City of Portland, Maine - Building or Use Permit Application
 389 Congress Street, 04101 Tel: (207) 874-8703, Fax: (207) 874-8716

Permit No: 07-0258	Issue Date:	CBL: 342 B048001
------------------------------	--------------------	----------------------------

Past Use: Vacant Land	Proposed Use: Single Family amend permit # 06-1192 changing from a 24' x 32 cape to a 24' x 32' colonial	Permit Fee: \$120.00	Cost of Work: \$10,000.00	CEO District:
Proposed Project Description: Amend permit # 06-1192 changing from a 24' x 32 cape to a 24' x 32' colonial		FIRE DEPT: <input type="checkbox"/> Approved <input type="checkbox"/> Denied	INSPECTION: Use Group: Type	
		Signature:	Signature:	
PEDESTRIAN ACTIVITIES DISTRICT (P.A.D.)				
Action <input type="checkbox"/> Approved <input type="checkbox"/> Approved w/Condition <input type="checkbox"/> Denied				
Signature: Date:

Dept: Zoning	Status: Approved with Conditions	Reviewer: Ann Machado	Approval Date: 03/23/2007
Note:	Ok to Issue: <input checked="" type="checkbox"/>		
<p>1) This property shall be a single family dwelling. Any change of use shall require a separate permit application for review and approval.</p> <p>2) As discussed during the

RIGHT ELEVATION

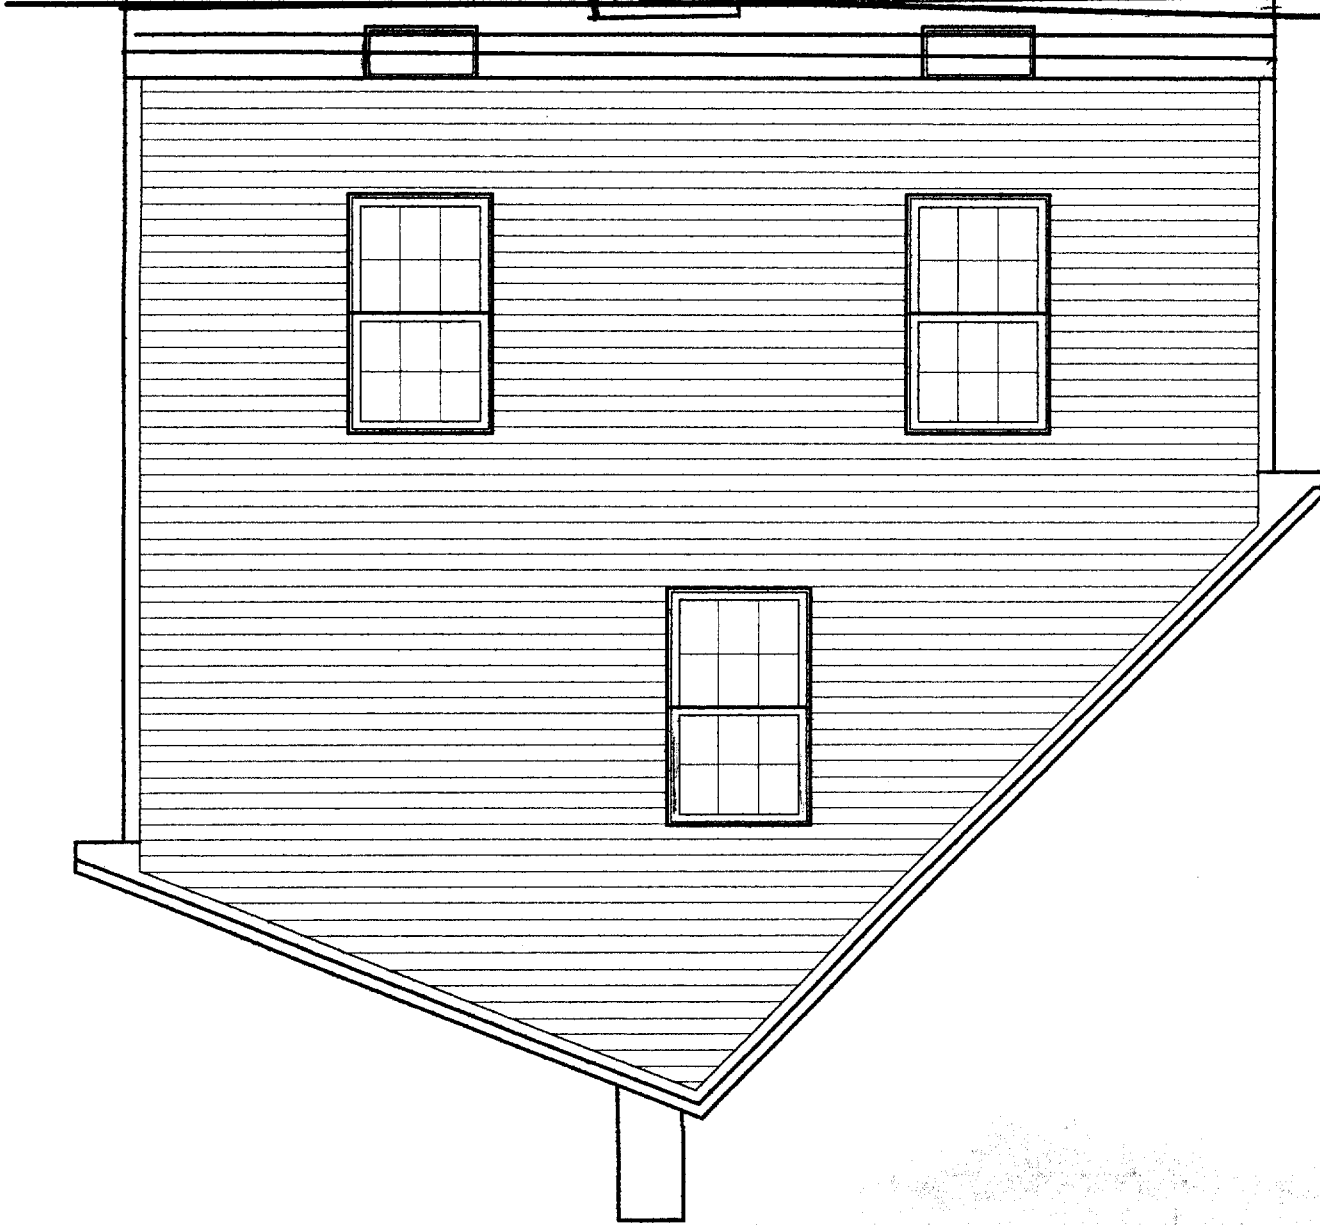
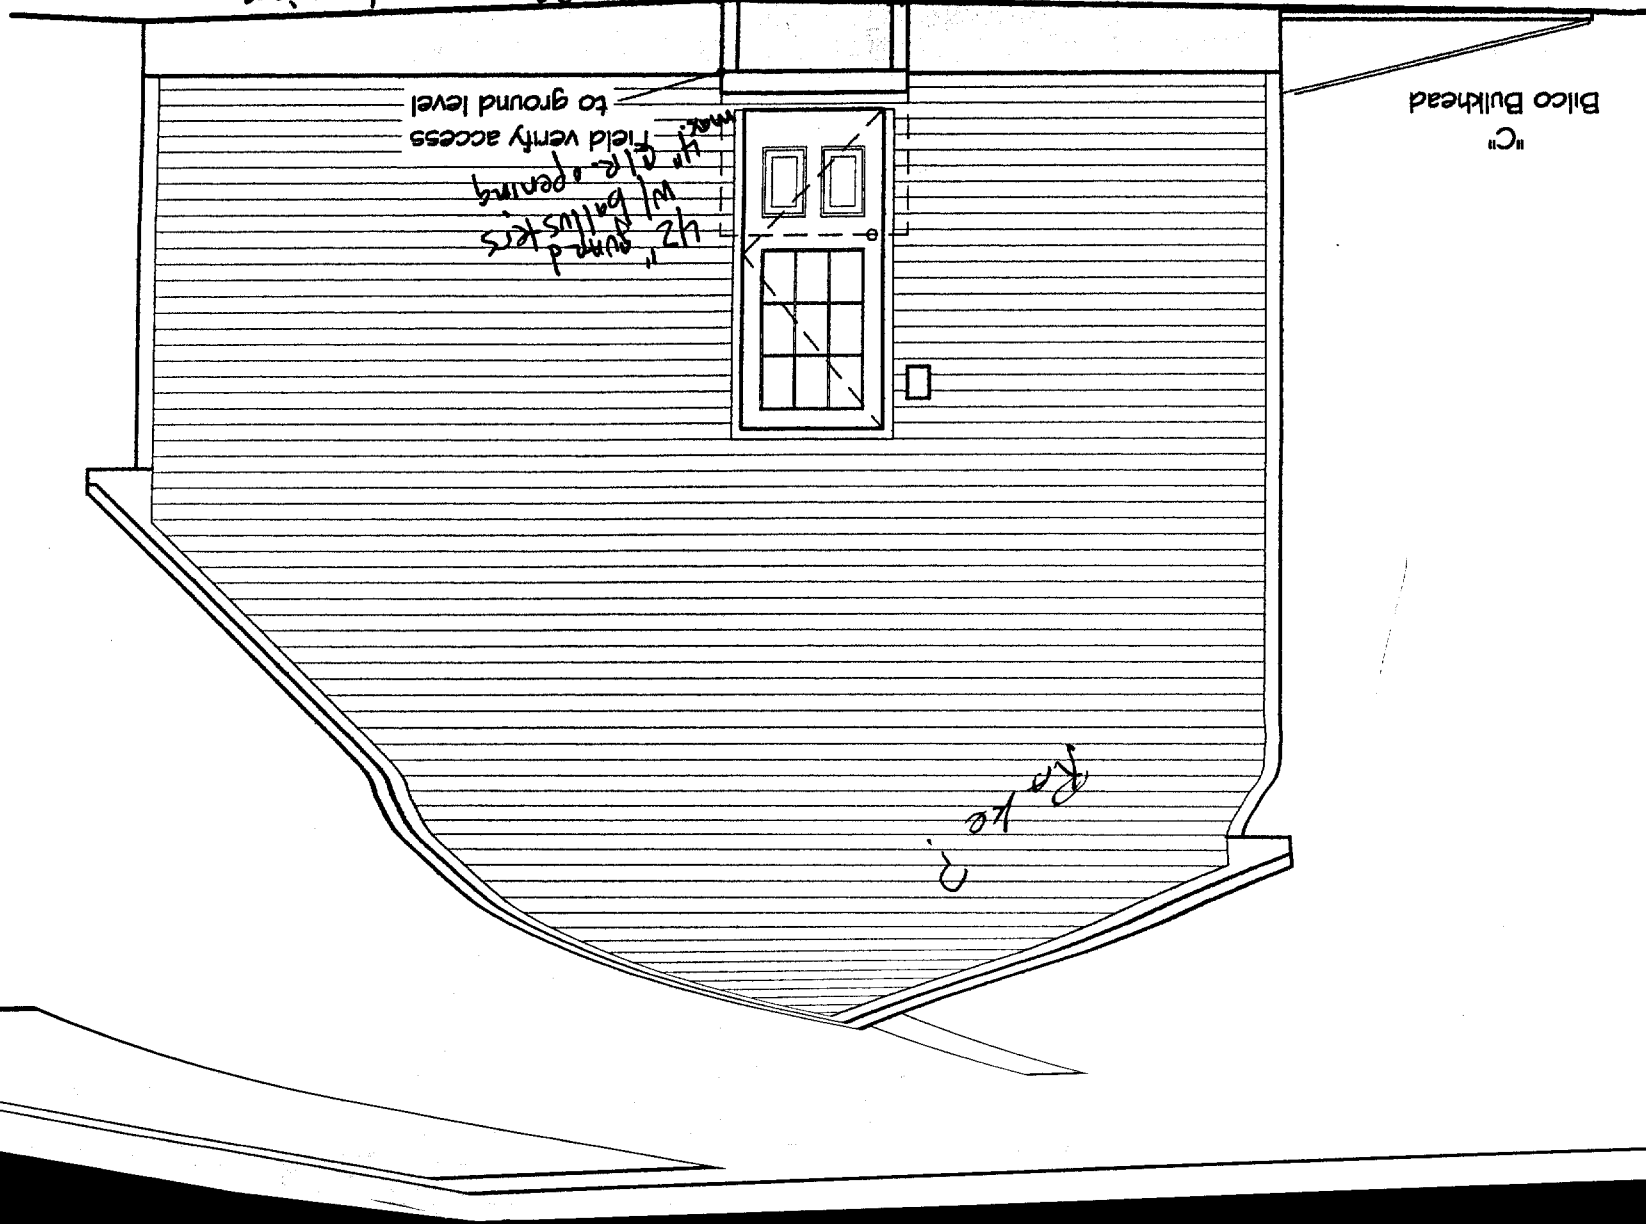
3/15/2007-amachado: Spoke to Ted. Told him that the building plans submtted with the amendment did not exactly match the original building plans. Some of the building projections and elevation plans were different. I told Ted that we needed a new site plan that matched the building plans submitted with the amendment.

RUBY LANE

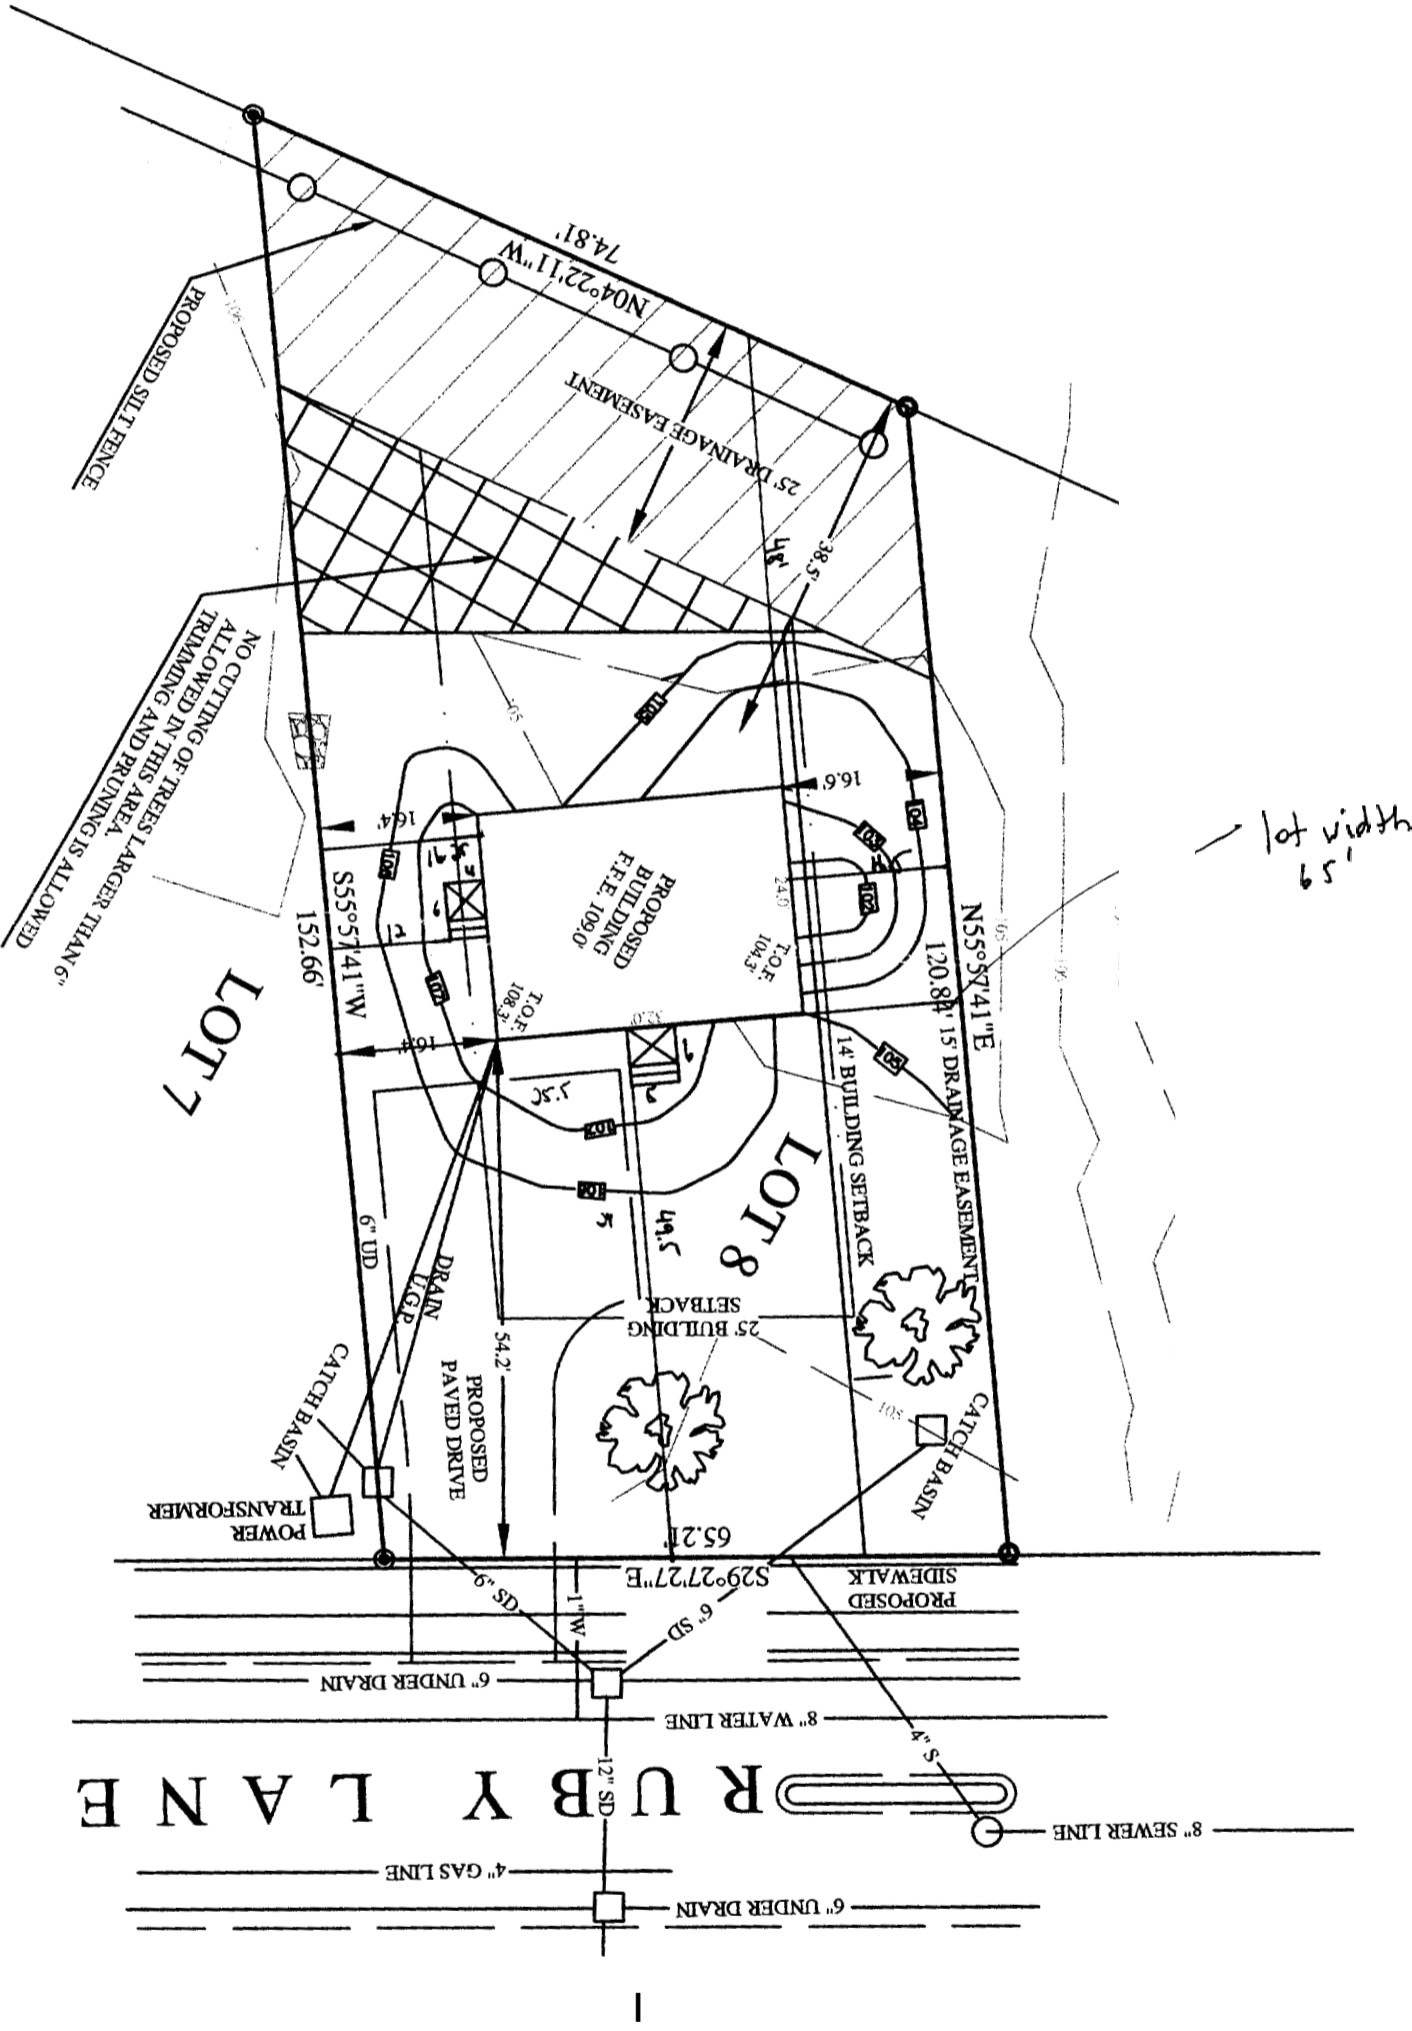
3/20/2007-amachado: Ted brought in a revised site plan yesterday. It is not to scale, it is not stamped and the elevations still don't match the buidling elevations completely. Left a message for Ted.

3/22/2007-amachado: Ted brought in revised plan that matches building plans.
